Item No. **Report of the Head of Planning, Transportation and Regeneration**

Address COLUMBUS VICTORIA ROAD RUISLIP

Development: Installation of a 20m monopole, 12 antenna apertures, 7 equipment cabinets and development ancillary thereto.

LBH Ref Nos: **75575/APP/2020/1478**

265 MAX CONFIGURATION ELEVATION

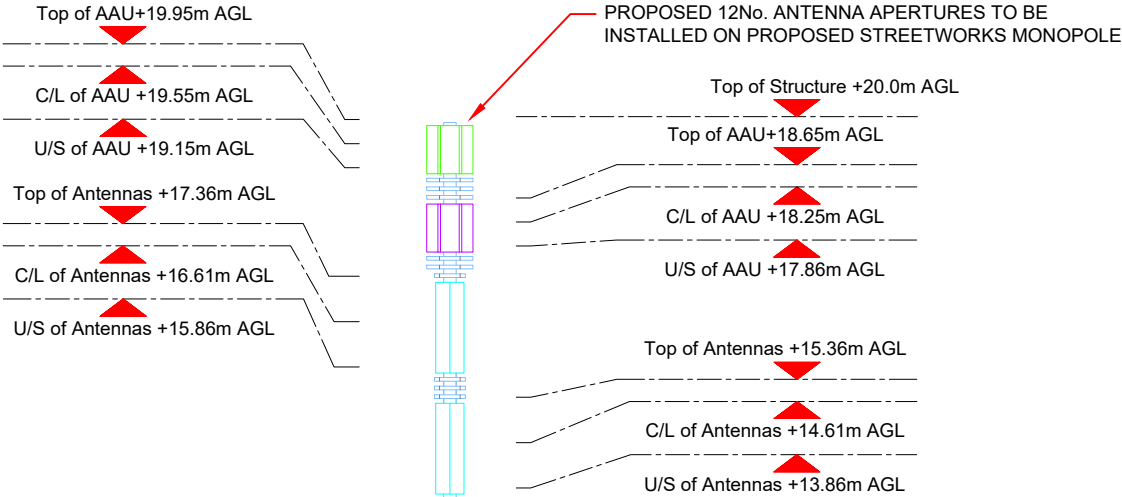
The proposal is considered to be an obtrusive form of development which would add visual clutter to the street scene. The proposal would not harmonise with the character of the area and would be detrimental to local visual amenities. As such, fails to comply with Policy DMHB 11 and DMHB 21 of The Local Plan: Part 2 - Development Management Policies (2020) and the National Planning Policy Framework (2019).

The proposed monopole, by virtue of its size and siting, and the proposed cabinets, by virtue of their siting and number, would create an obtrusive form of development which would add visual clutter to the street scene. As such, the proposal would not harmonise with the character of the area and would be detrimental to local visual amenities, contrary to Policy BE1 of the Hillingdon Local Plan: Part One - Strategic Policies (November 2012) and Policies DMHB 11, DMHB 12 and DMHB 21 of the Hillingdon Local Plan: Part Two - Development Management Policies (2020).

The site is within a commercial area but directly opposite a residential area generally comprising two storey semi-detached dwellings. The nearest dwelling is approximately 28 metres away. Whilst it is not considered that any material loss of amenity could be demonstrated, the siting and scale means that the development would be visible from a number of properties.
